Our Ref: WA/113/18/HH

**Town & Country Planning Act 1990 (as amended)
Town & country Planning (Development Management Procedure) (England) Order 2015
Application for Planning Permission for Works or Extension to a Dwelling**

Development Two storey rear extension, first floor side extension and conversion of garage to habitable use.

Location 9 Orchard Way Fontwell Walberton

Proposed East Elevation

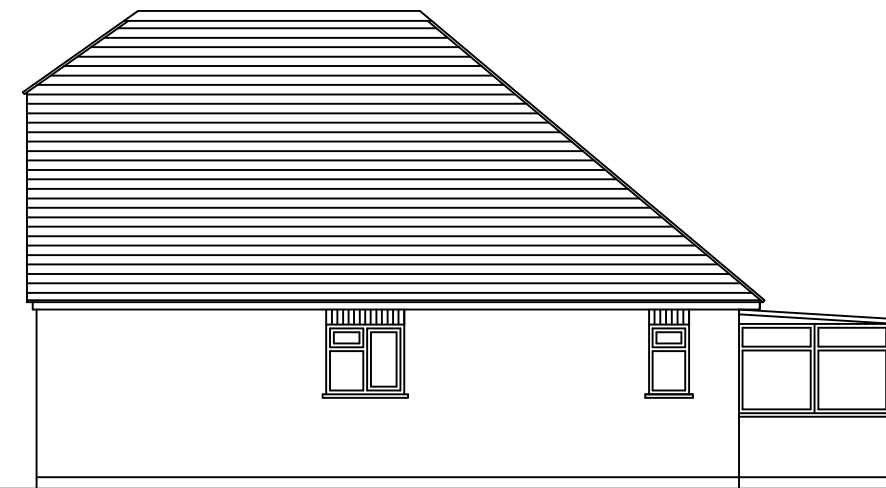
Windows Inconsistent: The windows do not match between the proposed ground floor and proposed east elevation. Please amend accordingly.
